An
Bord
Pleanála

Board Direction
BD-017898-24
ABP-316119-23

The Board decided to grant the Railway Order, generally in accordance with the Inspector's recommendation, for the following reasons and considerations, and subject to the following conditions.

Figure 5-65 Khyber Pass Footbridge Works

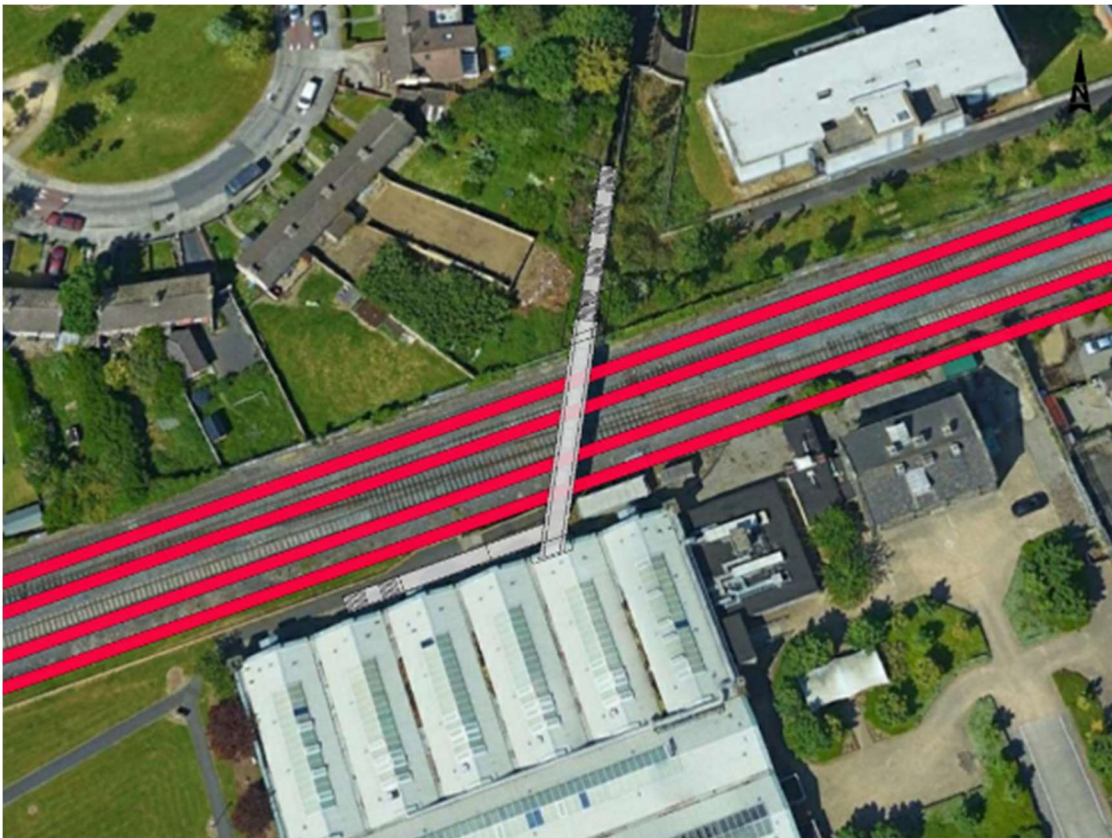
3. The removal of the Khyber Pass Footbridge is approved by this Railway Order. The replacement of the footbridge shall be omitted and shall not be developed in accordance with the submitted Railway Order application drawings and details. Where removed, the details of treatment of the area and approach, including landscaping, shall be submitted to and agreed with the planning authority (Dublin City Council) prior to the commencement of the development.

Figure 5-70 Boundary Wall and Toilet Block to be Removed

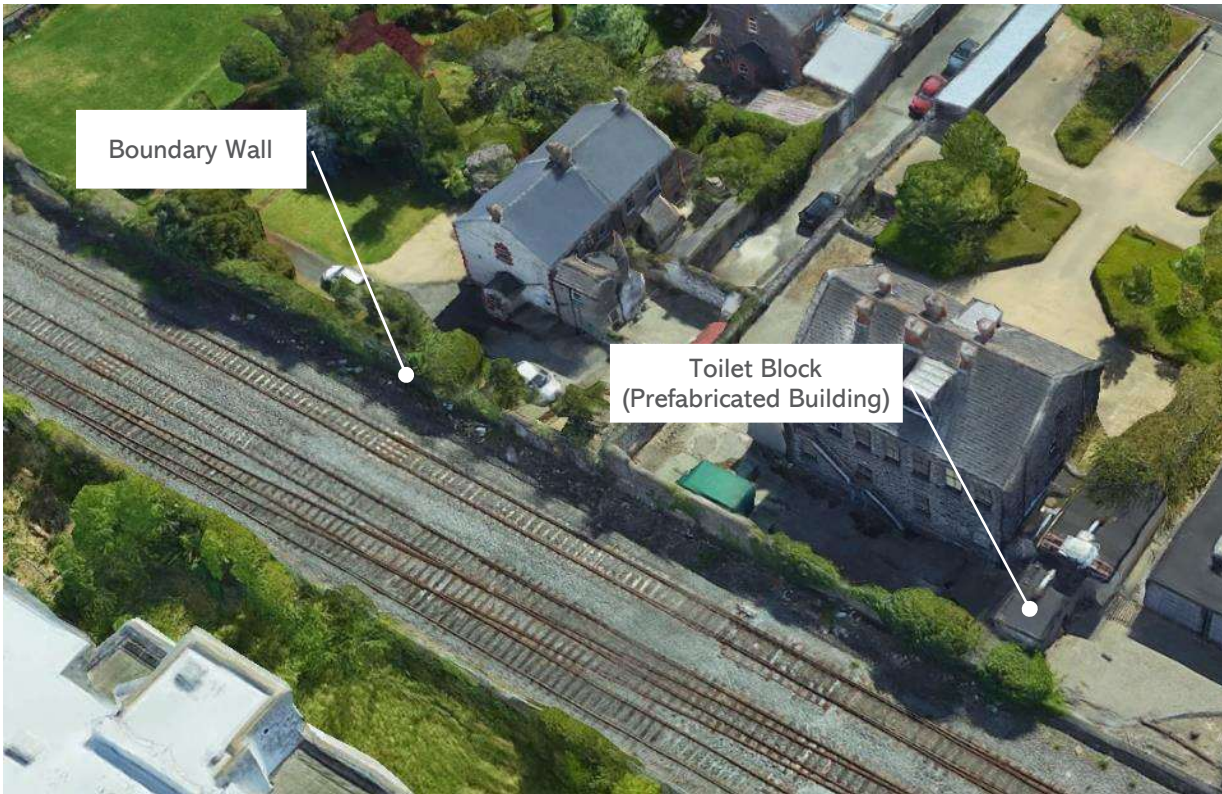
13. Prior to the commencement of development, the following details shall be submitted to Dublin City Council for written agreement:
- (a) details of the extent of masonry boundary wall to be removed within Inchicore Works,
 - (b) details of proposed interventions and/or repair of the abutments and associated retaining walls at Sarsfield Road Bridge,
 - (c) proposals, if necessary, for the underpinning of historic walls arising from the lowering of the railway track at Conyngham Road (BH-81), the Phoenix Park Tunnel (BH-82), the Royal Canal and LUAS Twin Arch Bridge (BH-12) and the Maynooth Line Twin Arch (BH-115),

Figure 5-117 Proposed Heuston West Station Layout

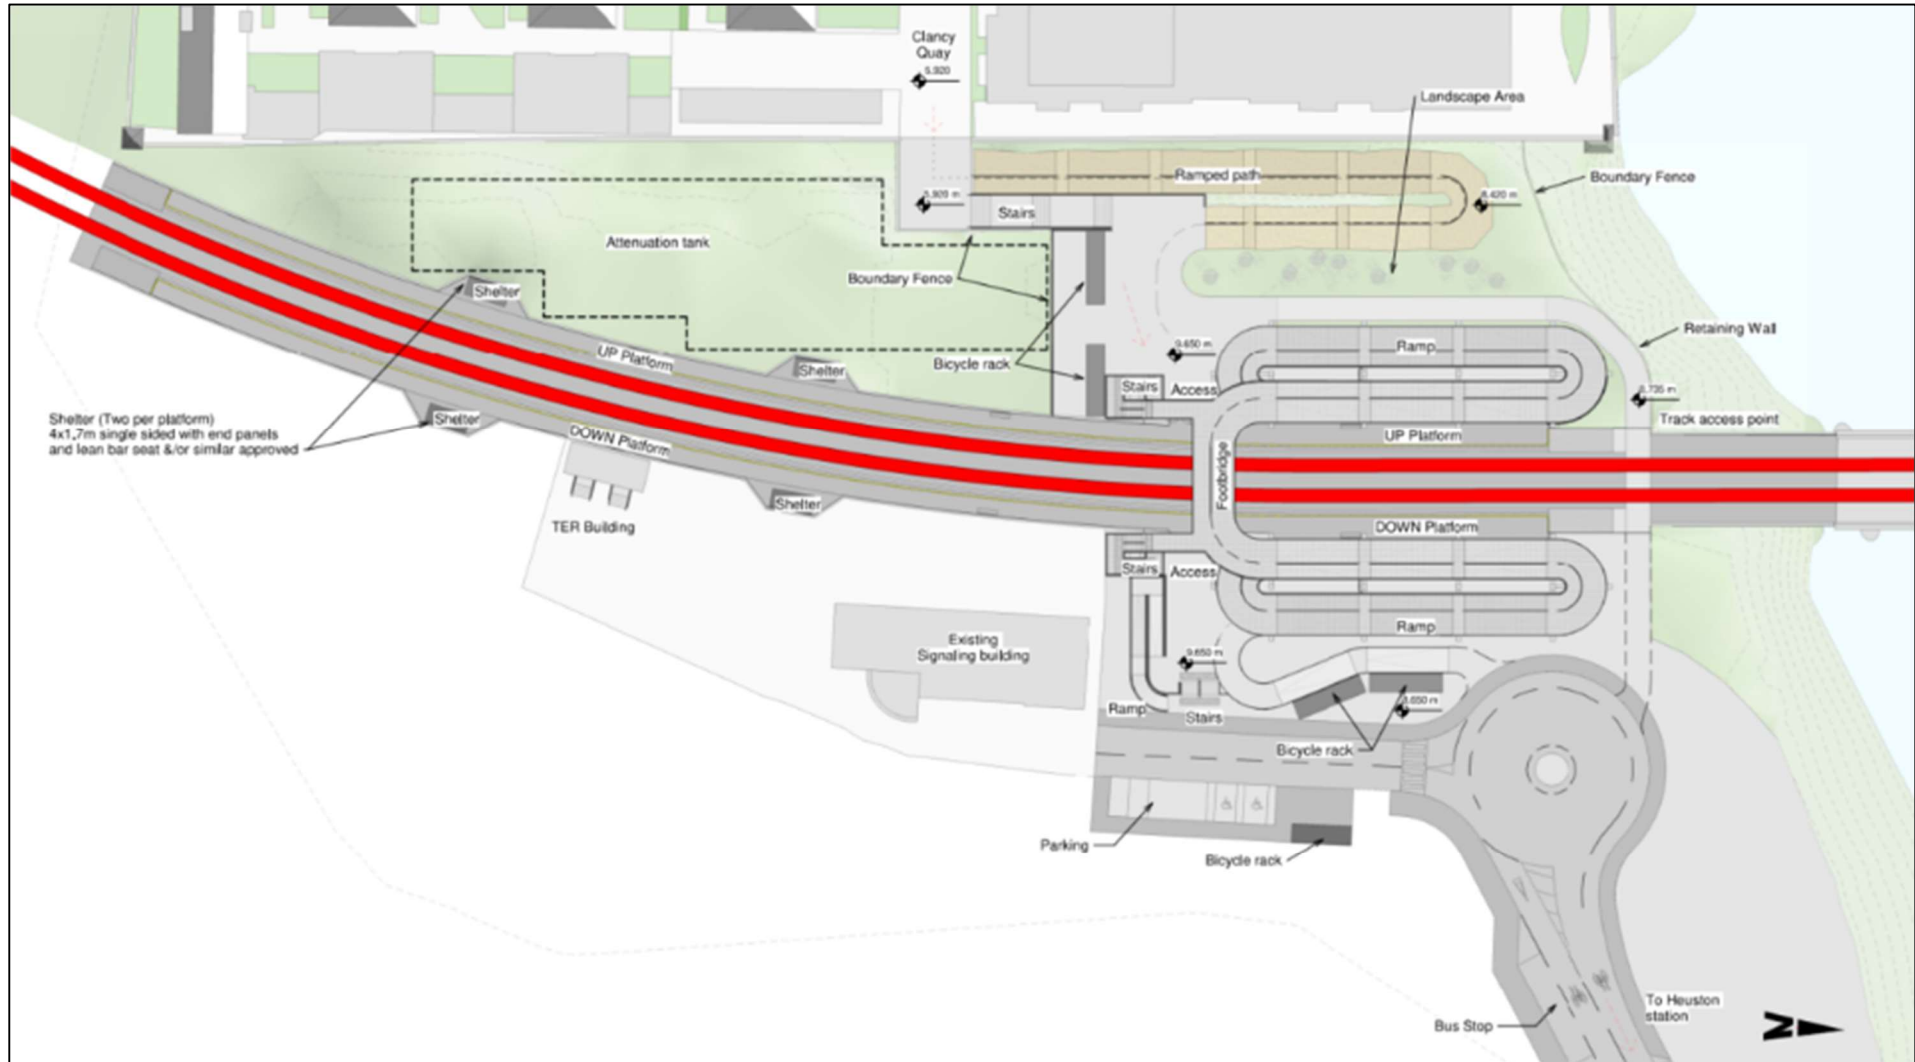
- 9. Prior to commencement of development, plans, specifications and details of the following shall be submitted to Dublin City Council for written agreement in respect of the proposed Heuston DART station:

- (a) provision of lift access to each platform at the new DART station,
- (b) proposed pedestrian and cyclist connections and associated works from the new DART station to the main Heuston Station concourse and Heuston Luas stop, and,
- (c) proposed pedestrian and cyclist connections and associated works from the new DART station to South Circular Road via Clancy Quay.
